Fleurie Nursery, Lake Lane, Barnham
Drainage system - Annexe

1a - ADC Drainage Officer Recommendation and requirements

20.6.2022

WA/75/22/DOC

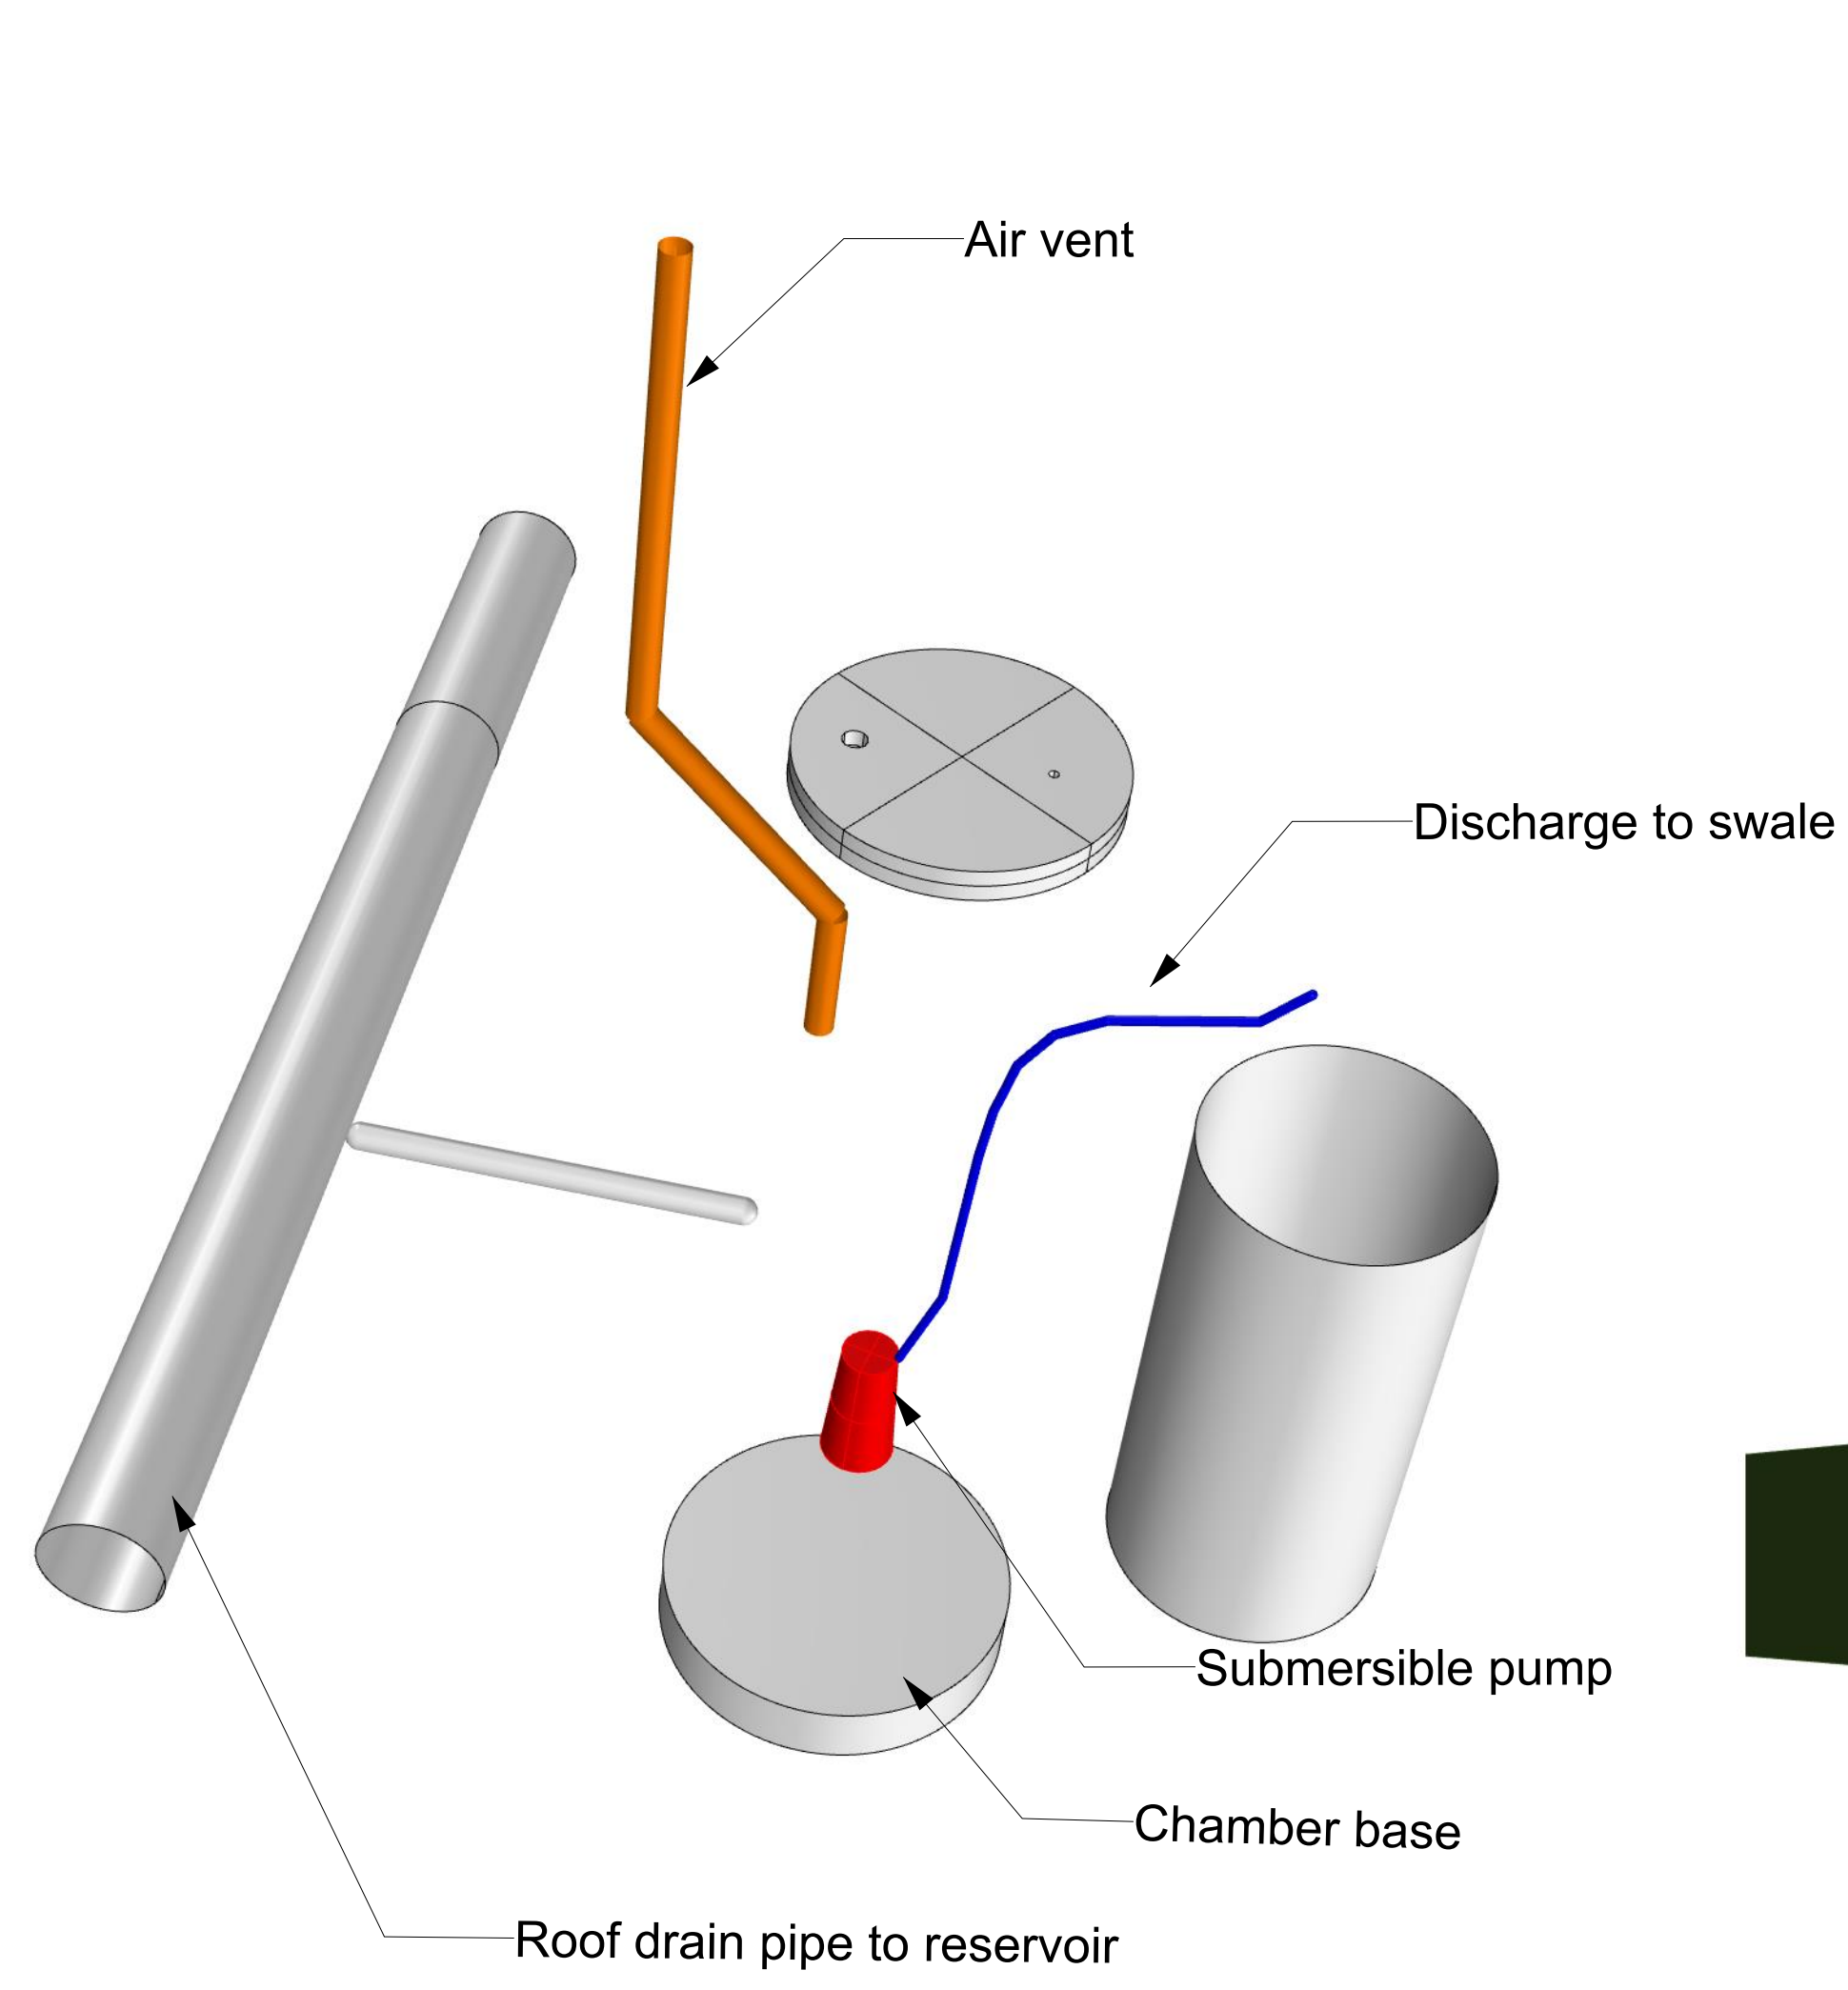
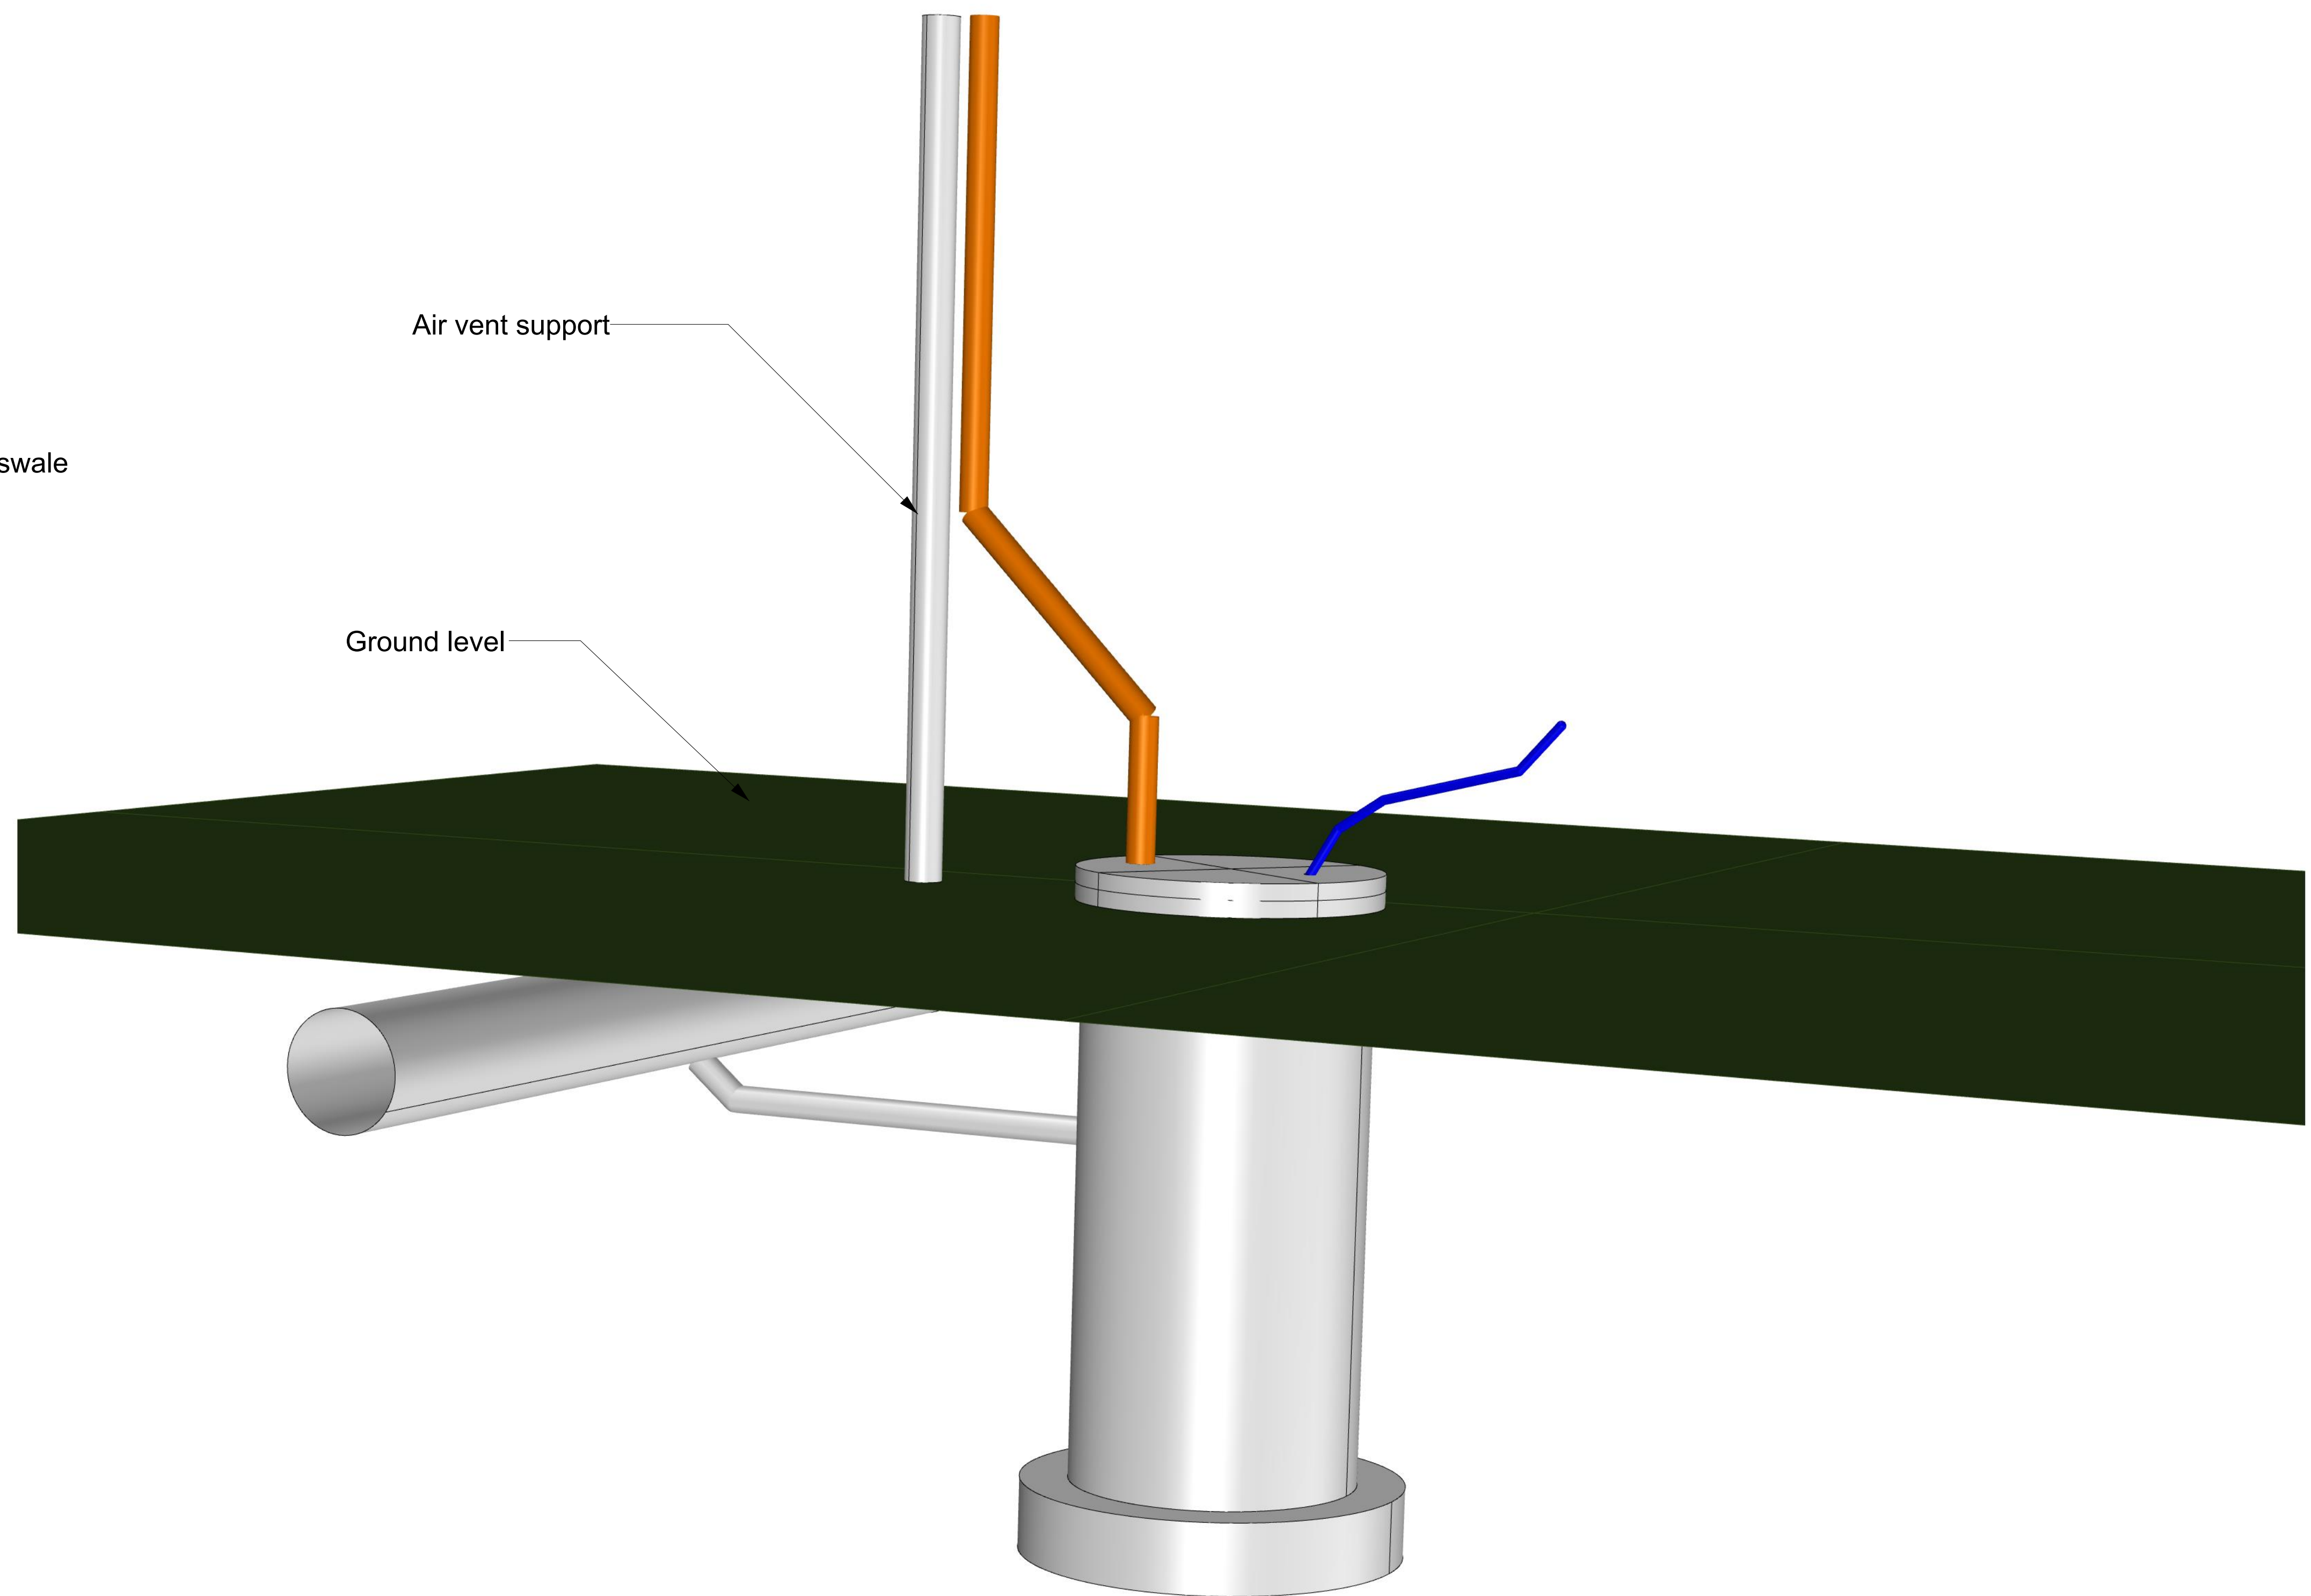
4) Details of exactly how the sump and pump system operate are required to better understand how this is used to drain down the outfall from each tank, and why this is required. This is to ensure that the tanks cannot be full prior to the onset of an extreme rainfall event.

- Full construction drawings in addition to the product specific schematics provided.
- Details of the pump.

This system is very simply used to reduce the amount of time that the drainage system sits flooded, it is not a part of the actual means that water gets from the greenhouses to the attenuation tanks nor a means of emptying the tanks, both of which are by gravity.

It comprises a 75mm connecting pipe from the main drain run, located at the low point near the tanks, to a sealed sump with a small submersible pump. This has a 25mm pipe taking the output into the tank.

After a rainfall event a flooded pipe system will sit with water in it up to a height of the outlet into the tank, unless a drain down pump is fitted. This pump simply drains down this water in the pipe so that it is not continuously sitting flooded. The discharge from the pump is into the tank, so nil effect on system capacity or discharge. If it fails it will have no impact on the system capacity.

A drawing of the sump is enclosed - "Drain down sump".
Pump make and model: Lowara DOC3.
